RE: Sweetwater Ranch CUP (CU-21-00002)

Re: SEPA Register 202101165, CU-21-00002

TO: Community Development Services  
FROM: Public Works Planning Review Team  
DATE: March 19, 2021  
SUBJECT: CU-21-00002 Sweetwater Ranch

SUBJECT: WDFW COMMENTS ON CU-21-00002 SWEETWATER RANCH

SITE PLAN

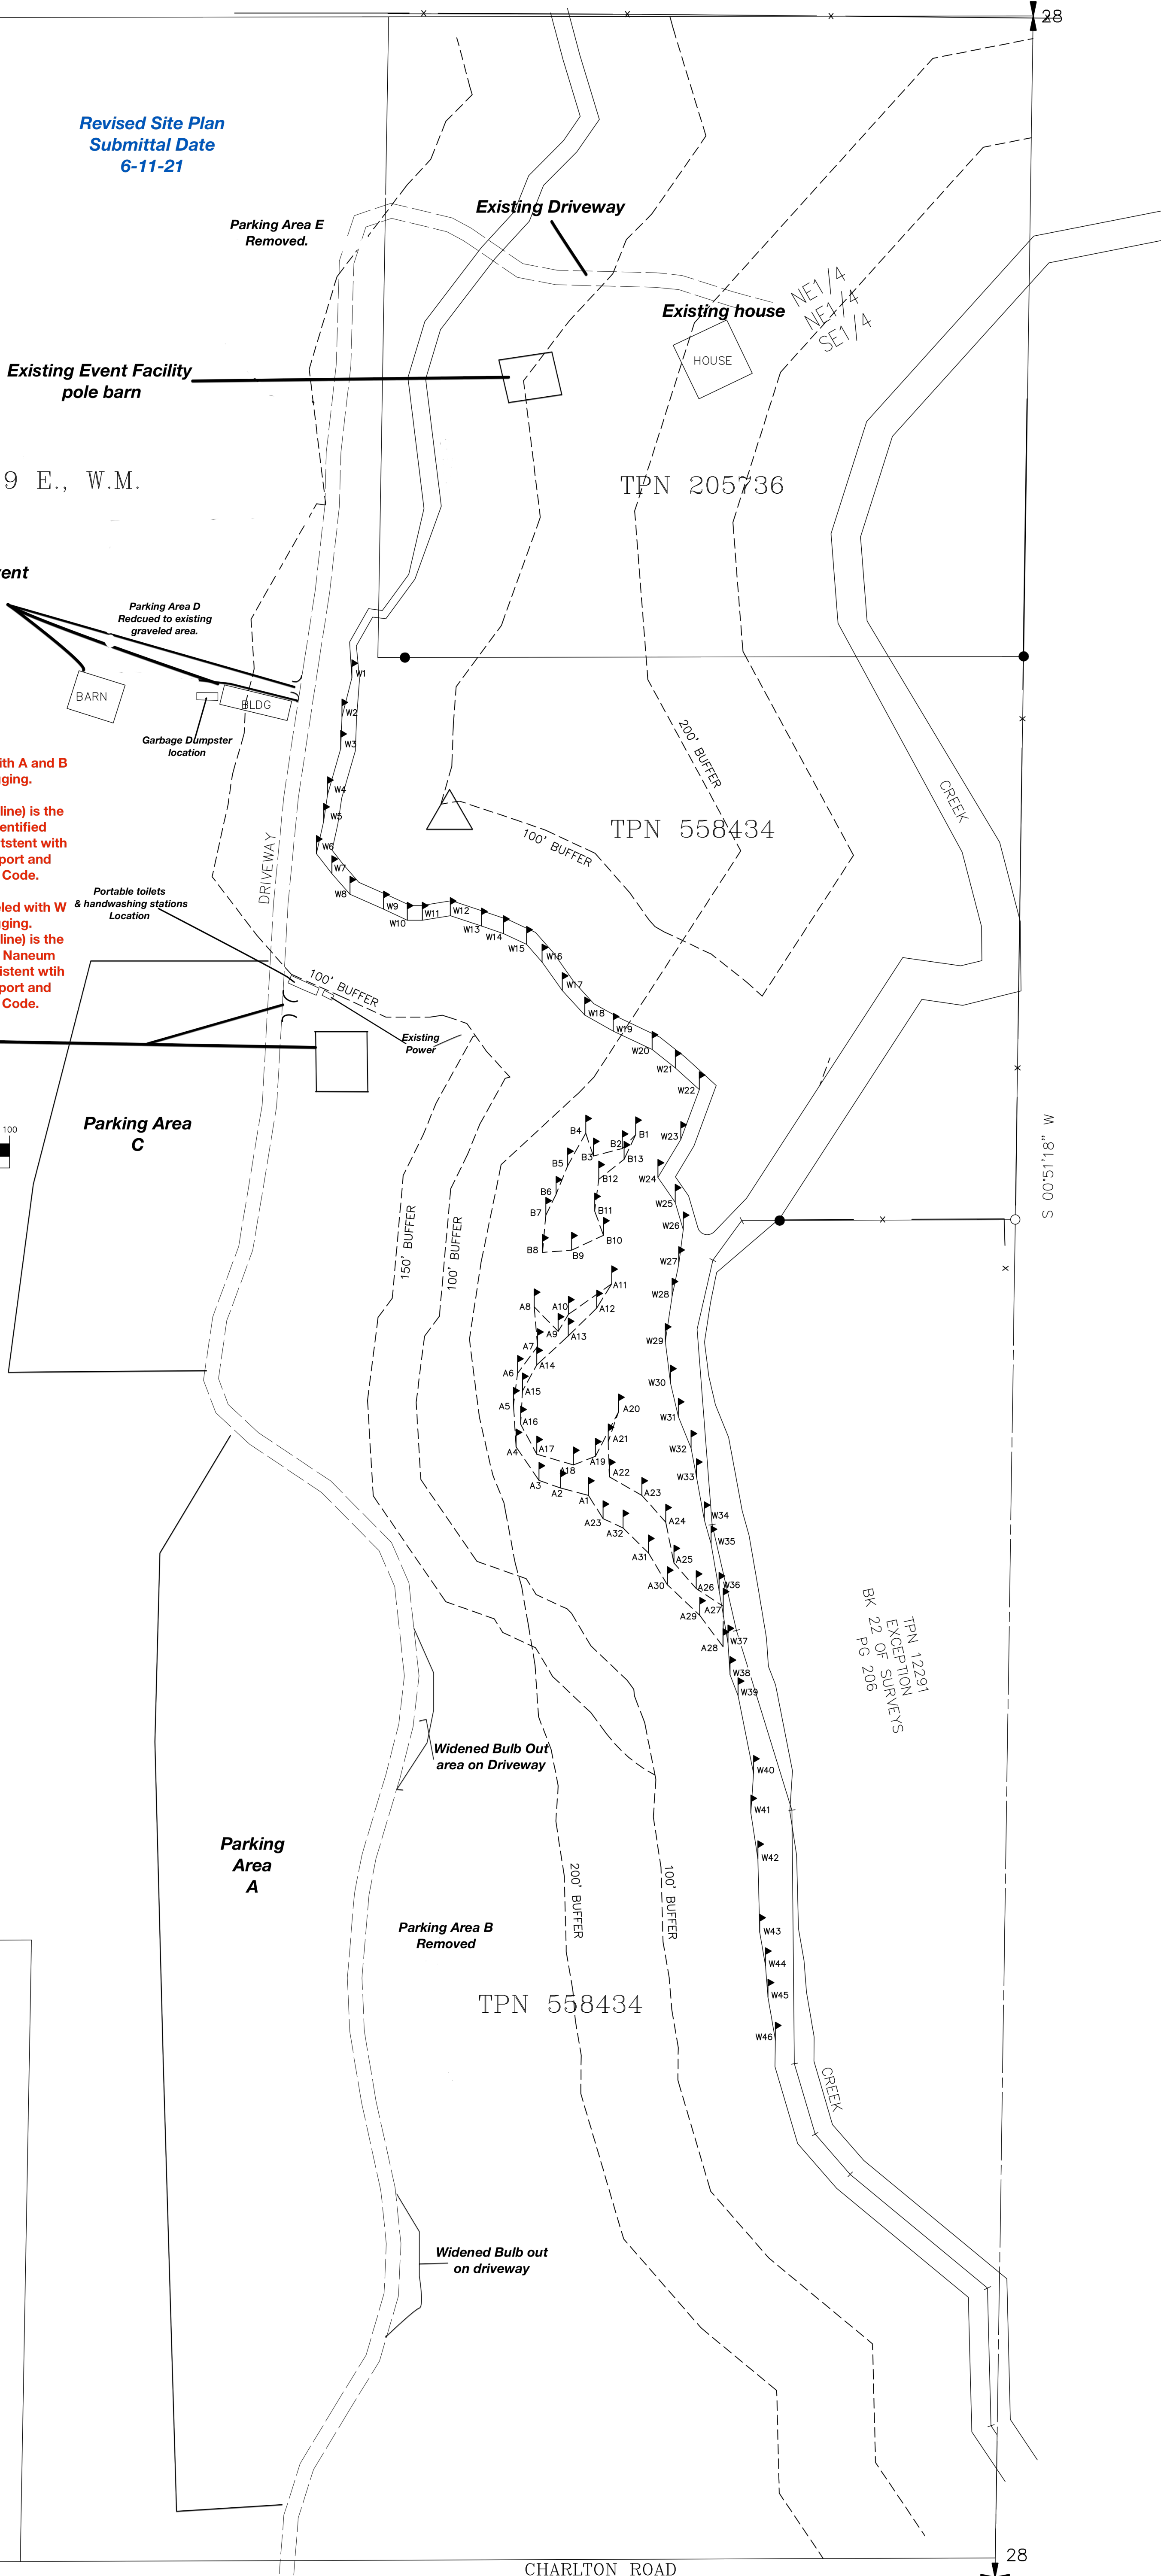
Upon conducting a desk review of the project area, reviewing the Critical Areas Report by Sewall Wetland Consulting Inc., and the site plan Ecology staff have some concerns with the proposed location of Parking Area B.

Ecology staff noted the wetland delineation was conducted outside the growing season, in November 2019, and the precipitation preceding the site investigation was not provided. Several areas of concern were observed on current and historical aerial imagery. Ecology would like to request a joint site visit to investigate the areas of concern and confirm the wetland boundary.

In addition, to the areas of interest and requested site visit, Ecology requests the County revisit the required wetland buffer for Category II associated wetlands under the Shoreline Master Program (SMP). The wetlands located on the parcel would be regulated under the Counties Shoreline Master Program (SMP). Per table 5.2-1, Wetland Buffers for Wetlands in Shoreline Jurisdiction, Category II wetlands in an area of high landuse intensity require a 200 foot wide buffer to properly protect the high functioning wetland. An event center with multiple parking needs, pedestrian foot traffic, etc. would be considered to be high intensity landuse and not low or moderate.

The proposed parking areas, particularly Parking Area D and E (and potentially C depending on the extent) are within priority shrubsteppe habitat and converting these areas to a parking area would result in loss of shrubsteppe habitat through clearing. Further, from aerial imagery there appears to be a drainage with some riparian vegetation going through these proposed parking areas that would be impacted. It is stated in the critical areas report that this is an irrigation ditch, yet no assessment of current habitat quality or function of that area is described. WDFW would like to understand the impacts of that drainage for fish and wildlife habitat. Parking Area B is next to a well vegetated area which the critical areas report identifies as an irrigation ditch. WDFW would like to understand the connection of that ditch to Naneum Creek and the implications of the parking area on the associated habitats here. WDFW requests that these parking areas either be configured to avoid these habitat impacts, or habitat mitigation proposed (such as enhancement of other habitat areas on the property)
